Your ref:
Our ref: 23/00599/A
Please ask for: Mrs Lesley Raby
Direct dial: 01553 616818
E-mail: borough.planning@west-norfolk.gov.uk

Details: **Advertising boards with dimensions of W900 x H600 at 78 Old Hunstanton Road
Old Hunstanton Hunstanton Norfolk PE36 6HX**

Signage  
Site Plan

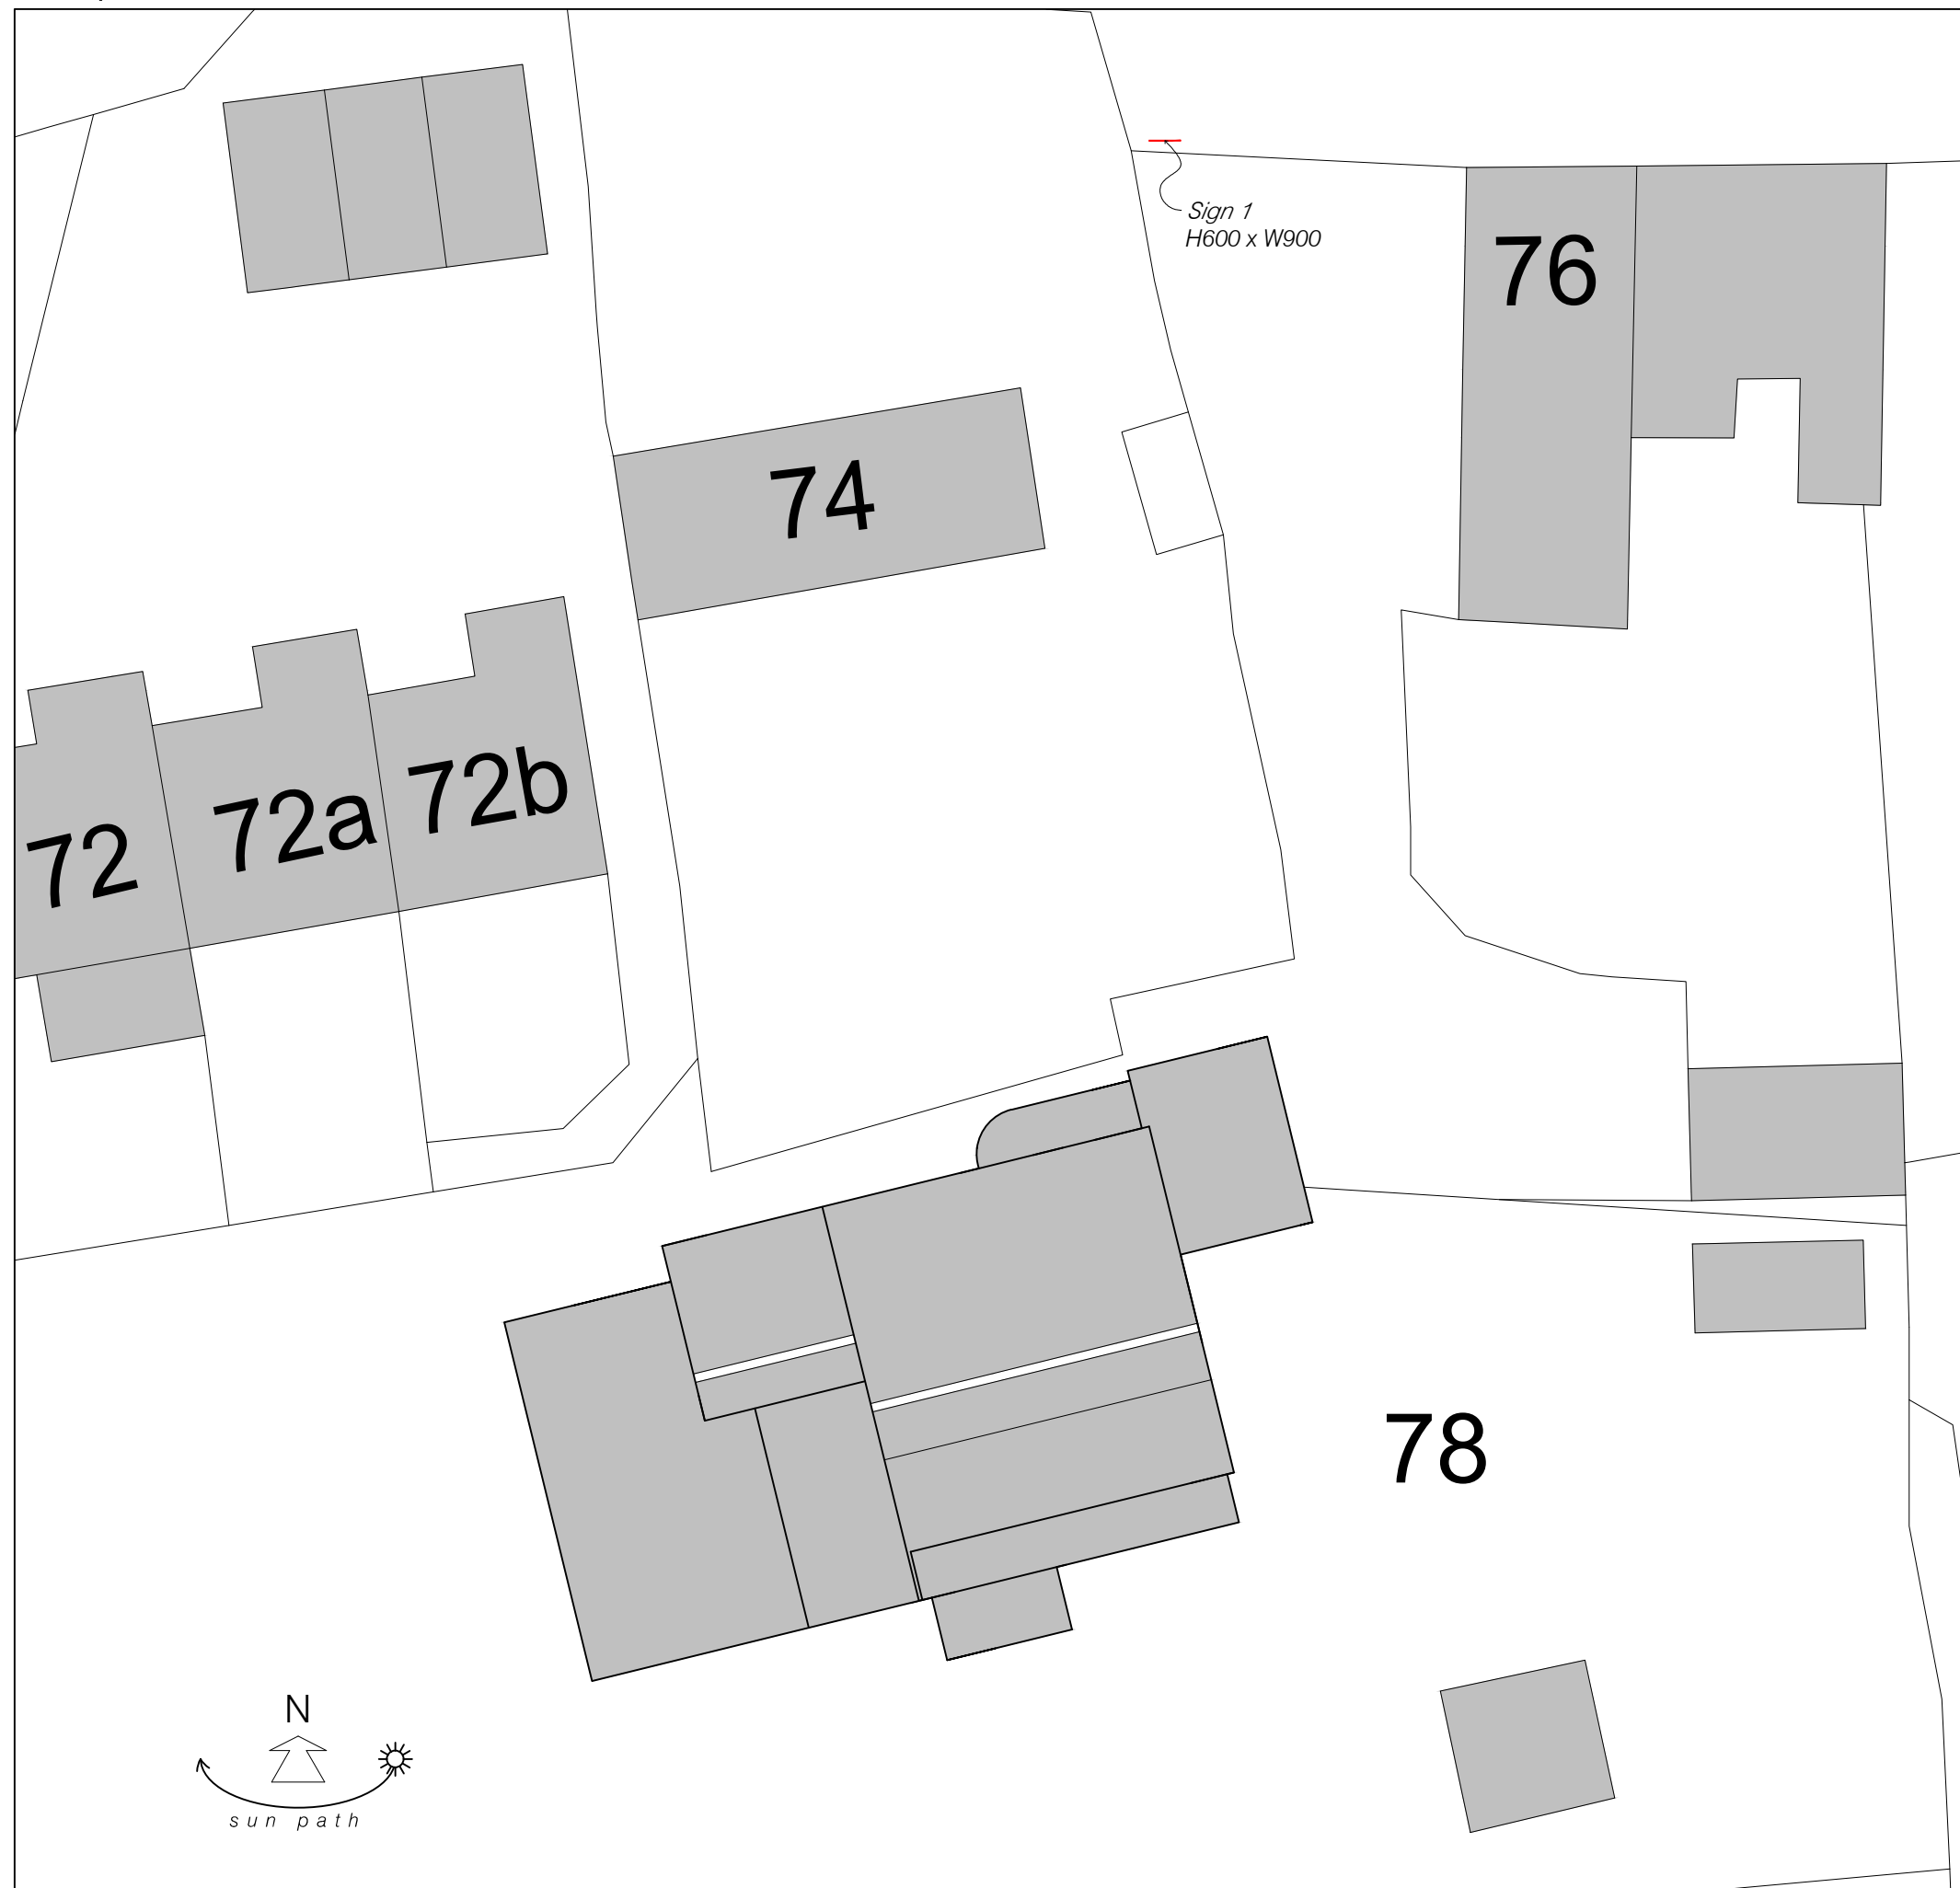
1. Provide a location plan to a scale of 1:1250 or 1:2500 with a red line around the application site.
2. The site plan shows the position of Sign 1 only. The plan 452-02 shows sign 1 and sign 2.
Where will sign 2 be sited?
